Application by Highways England for M54 to M6 Link Road

The Examining Authority's written questions and requests for information (ExQ1)

Issued on 20 July 2020

Drawing Title  
**WORK PLANS  
 REGULATION 5(2)(J)  
 SHEET 1 OF 10**

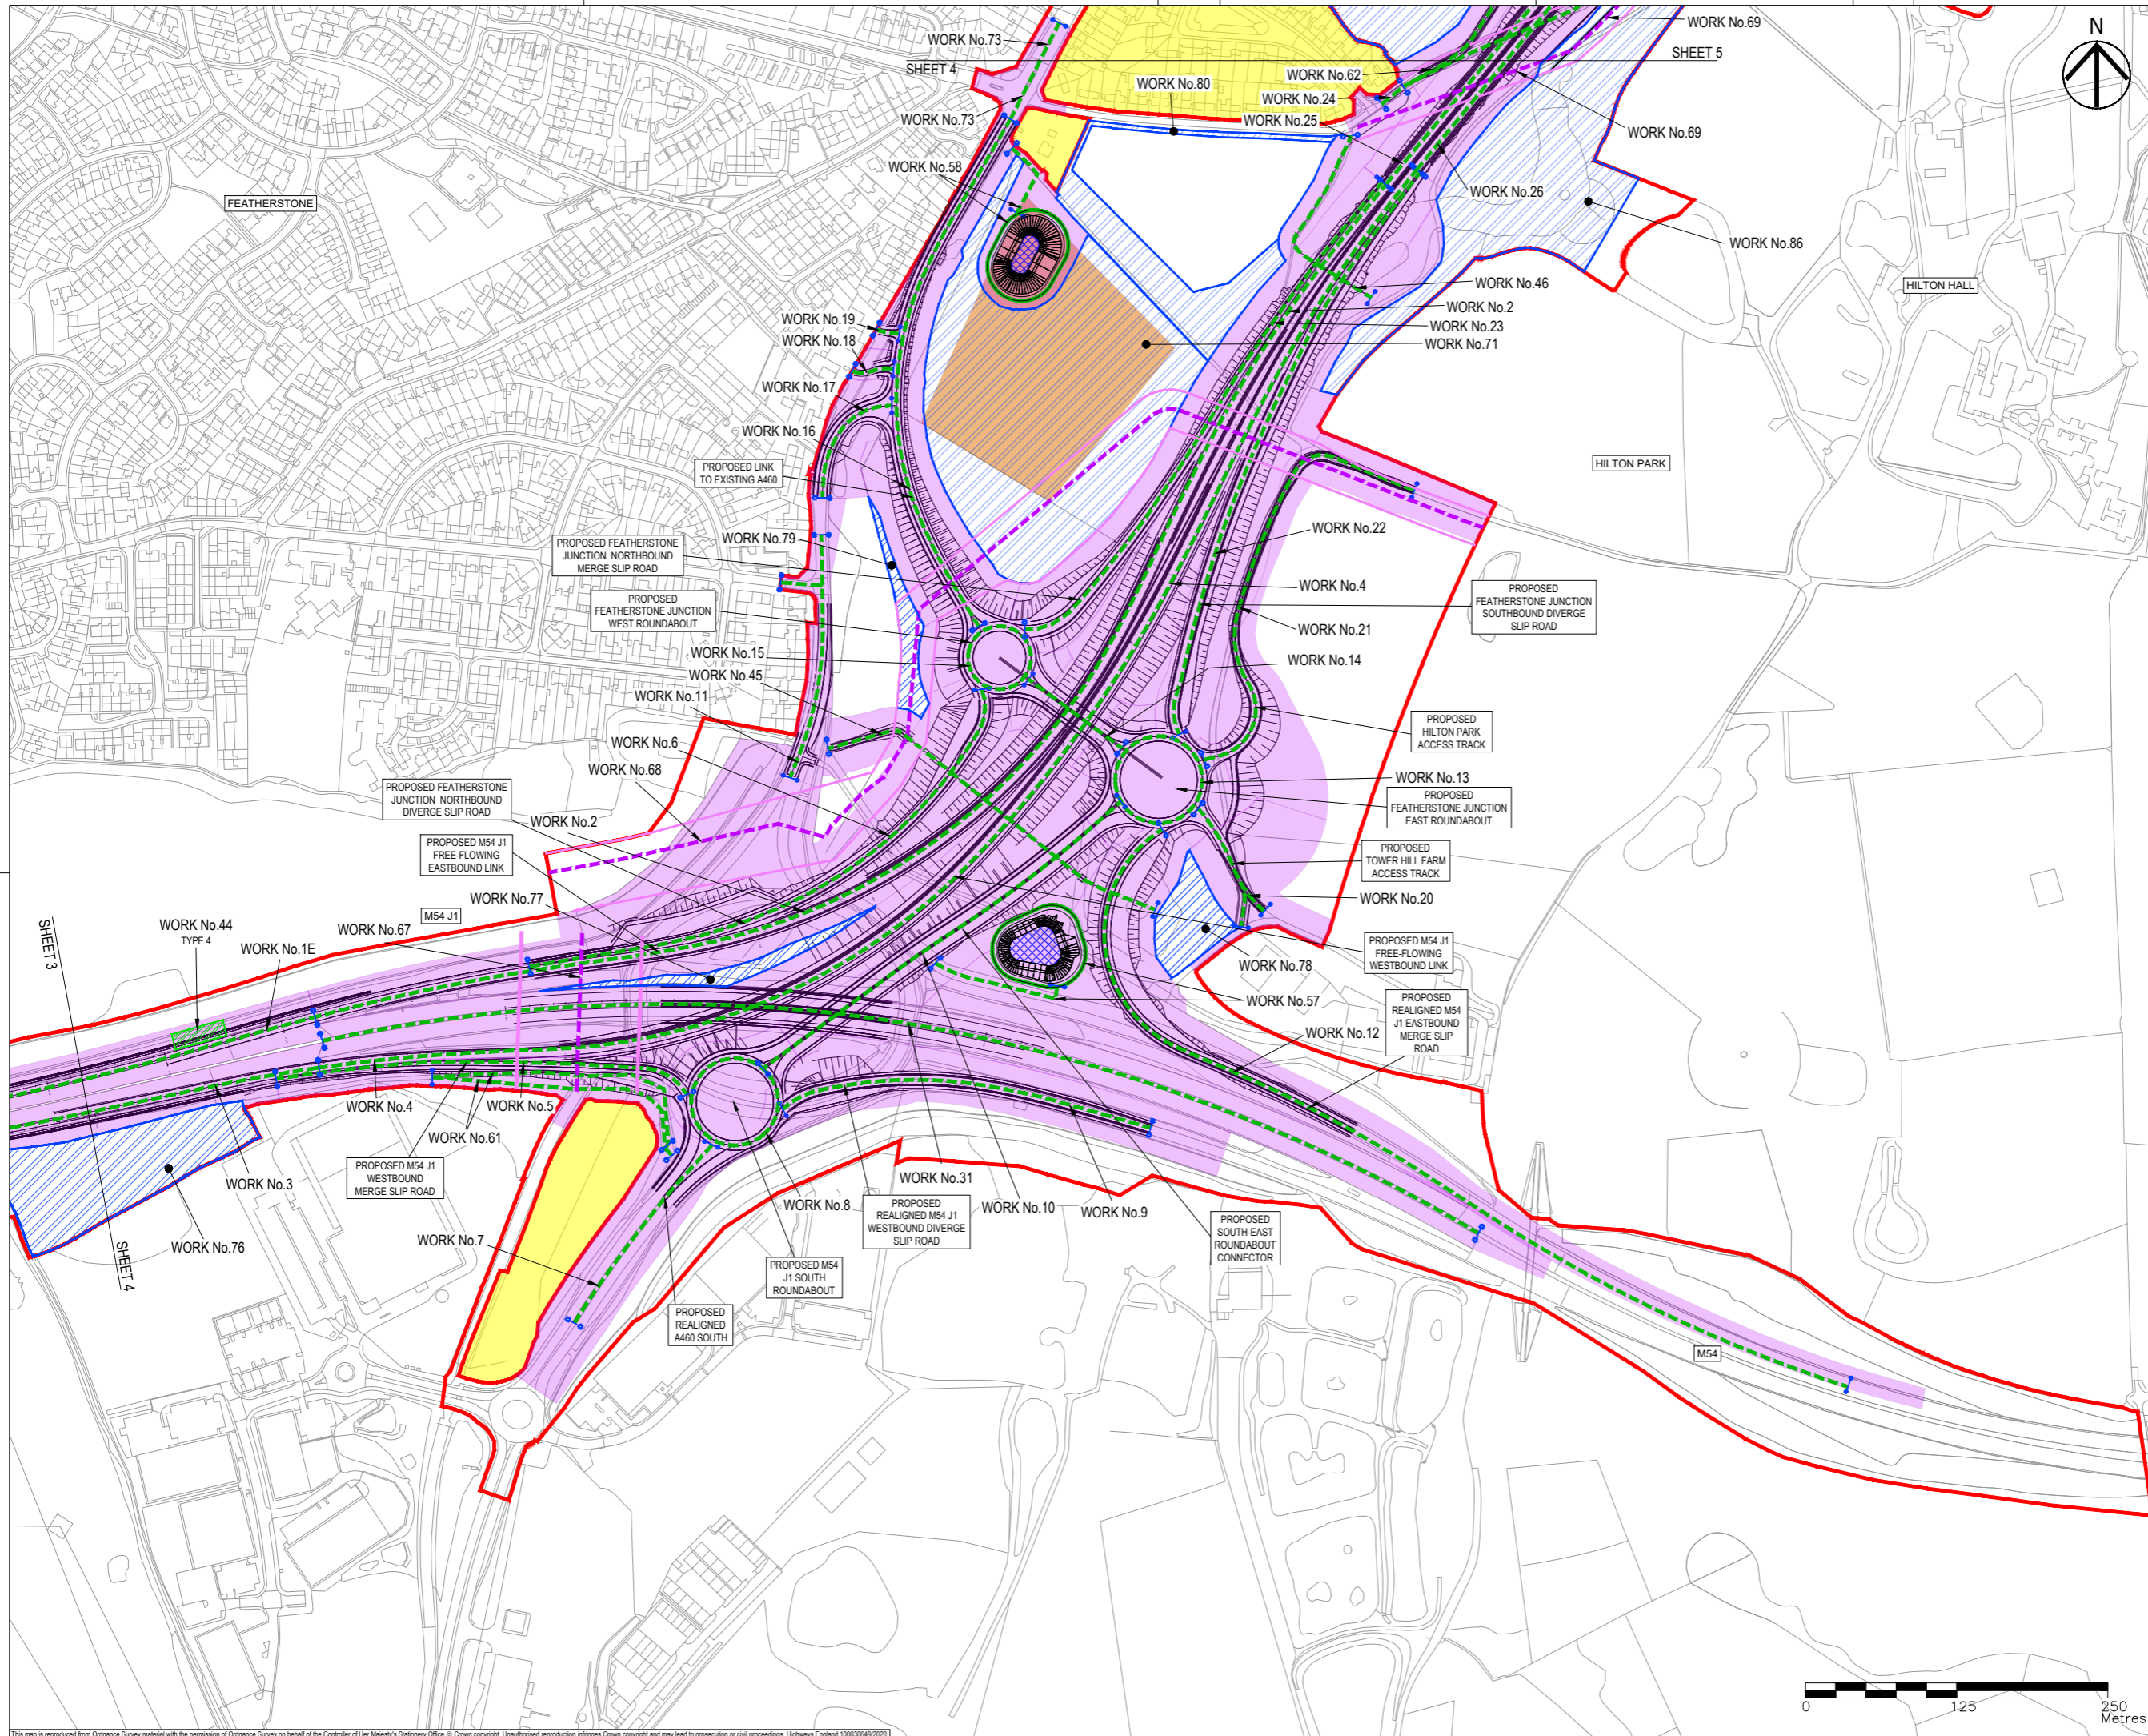
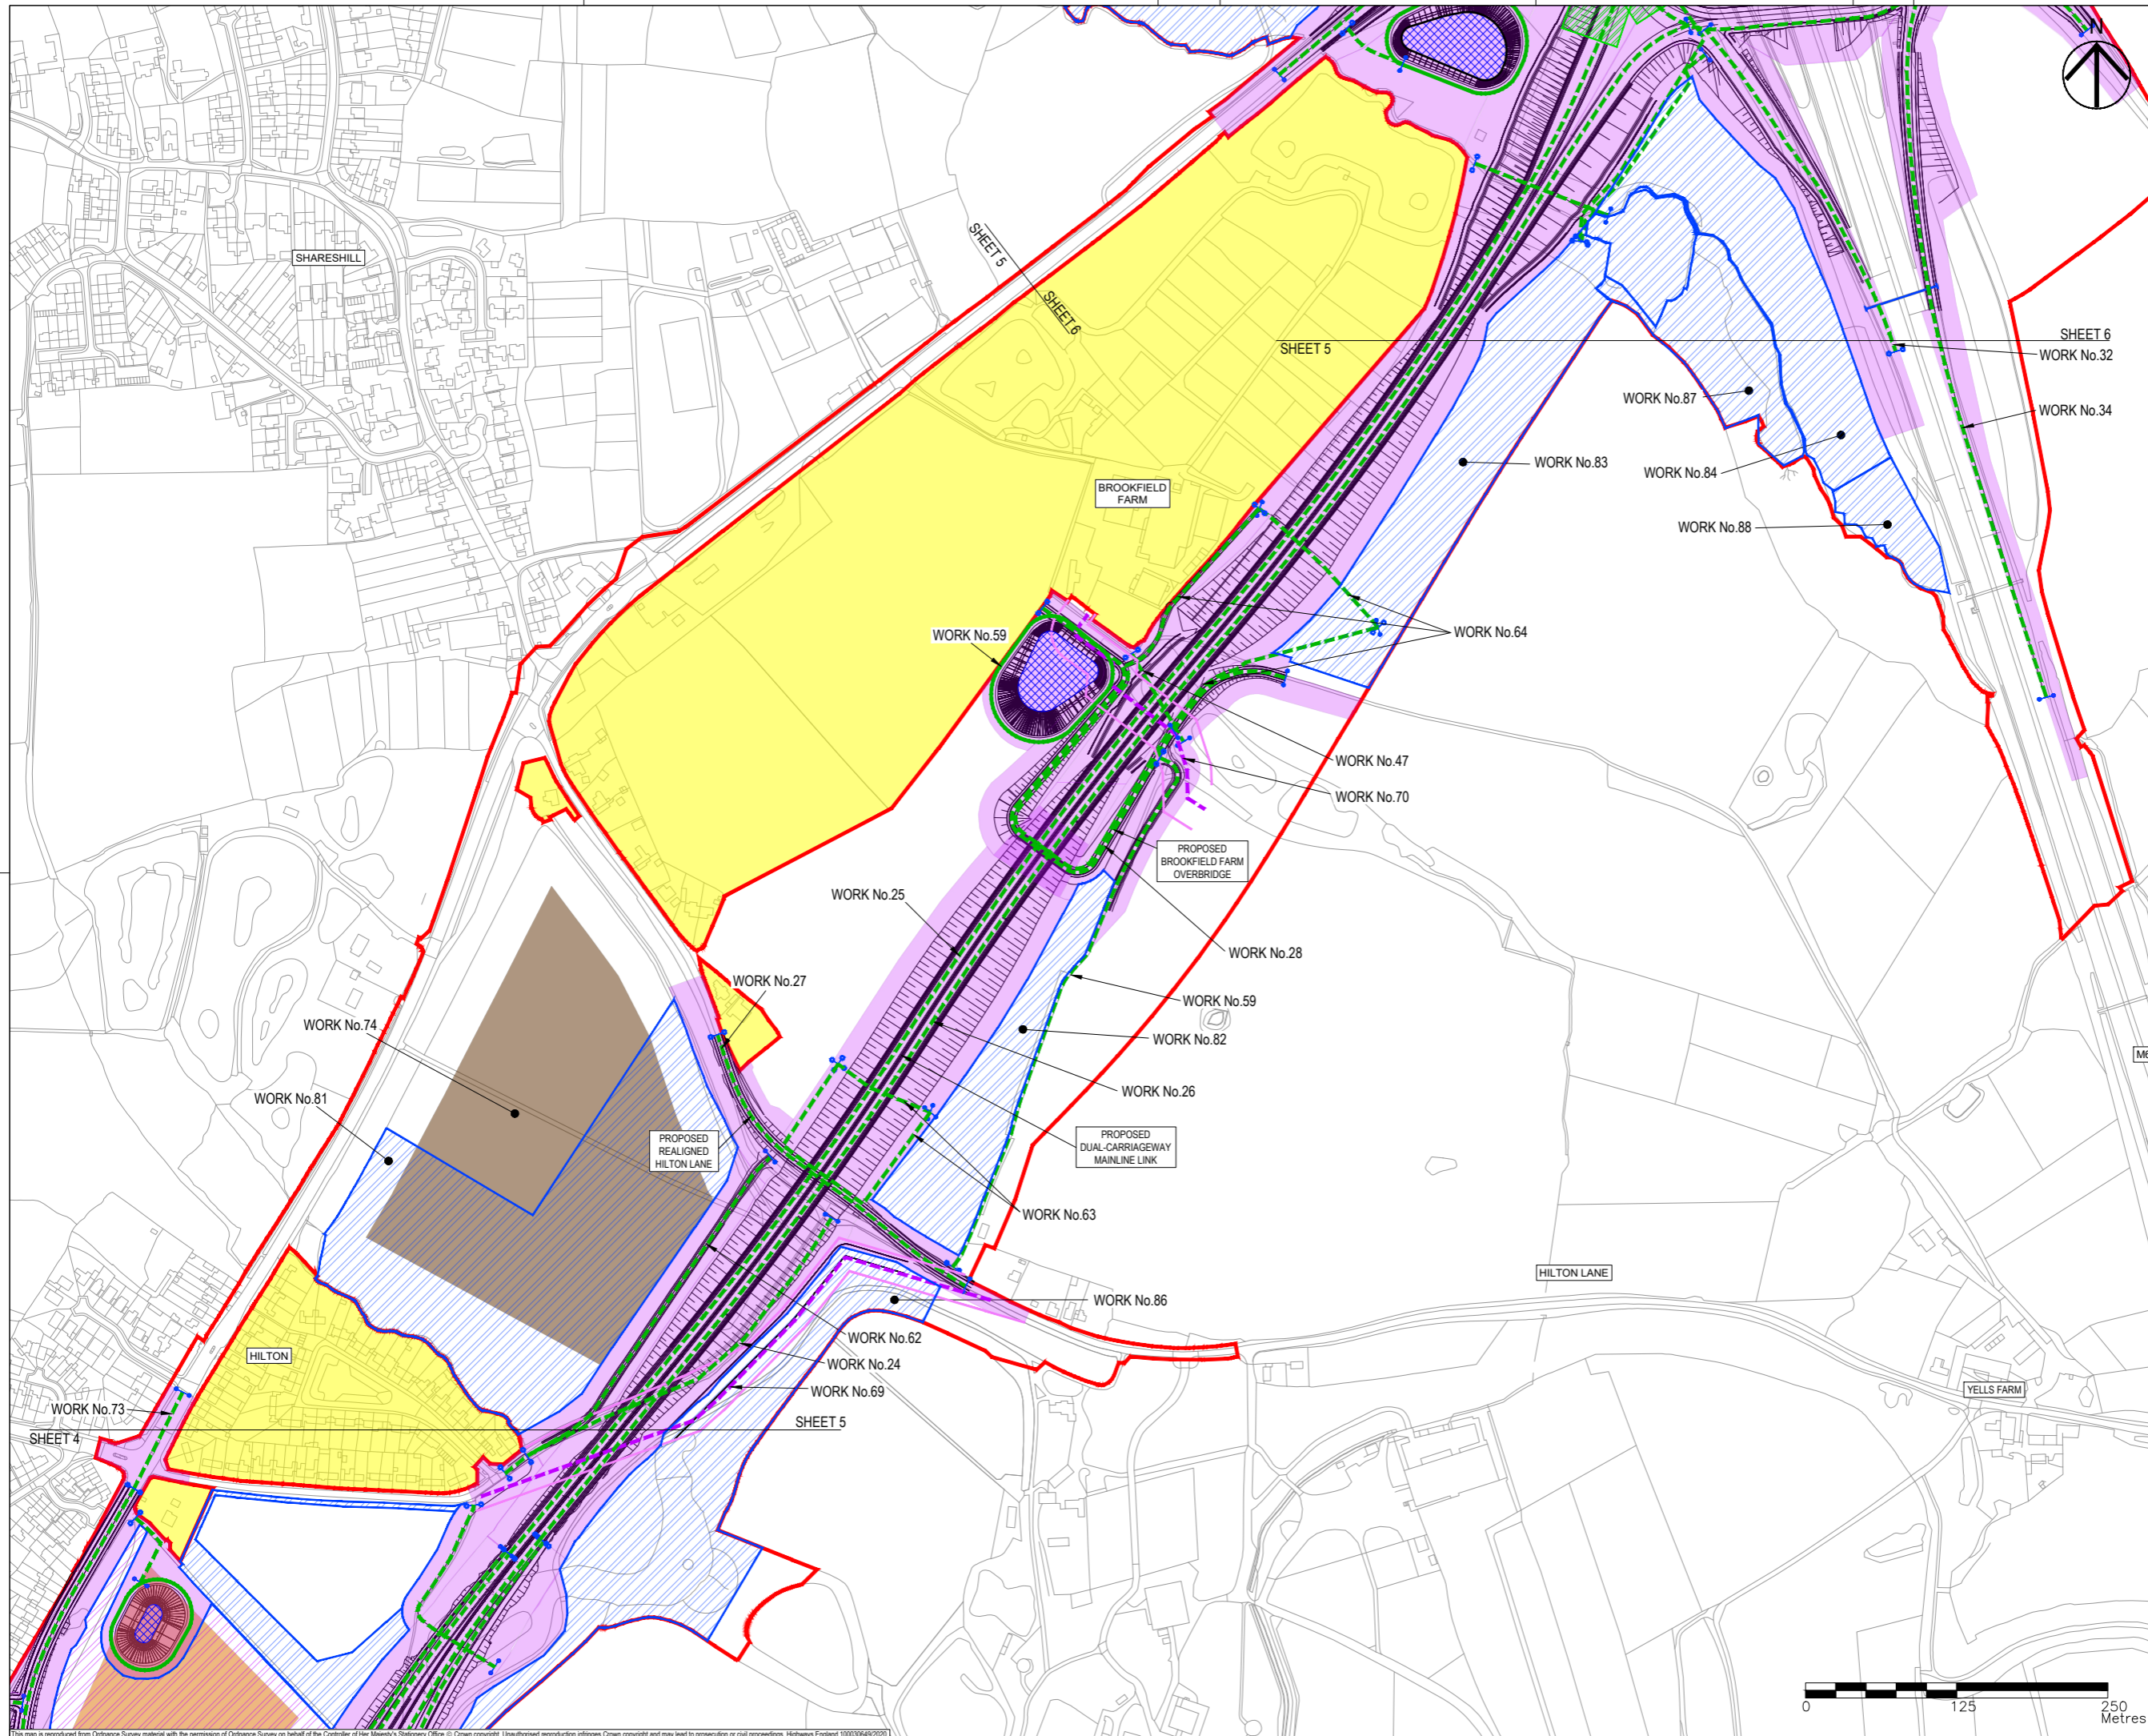
1.0.14	The Applicant	<p>Environmental Masterplan/Works Plans</p> <p>a) Can the Applicant clarify why certain areas of the Proposed Development as represented in the Works Plans red line boundary (within Sheets 1-3, and 6-10</p>

ExQ1	Question to:	Question:
		<p>[APP-057] to [APP-063], which include Works 1, 35, 41, 42, 51, 52, 53, 54, 55, 55A, 55B, and 55C) have not been fully represented in the Environmental Masterplan or in the Construction Works (ES Figure 2.9, [APP-065]) for the ES.</p> <p>b) Can the Applicant explain why these works are not represented on the Environmental Masterplan and the Construction Works plans and confirm that these works have been fully considered as part of the ES.</p>
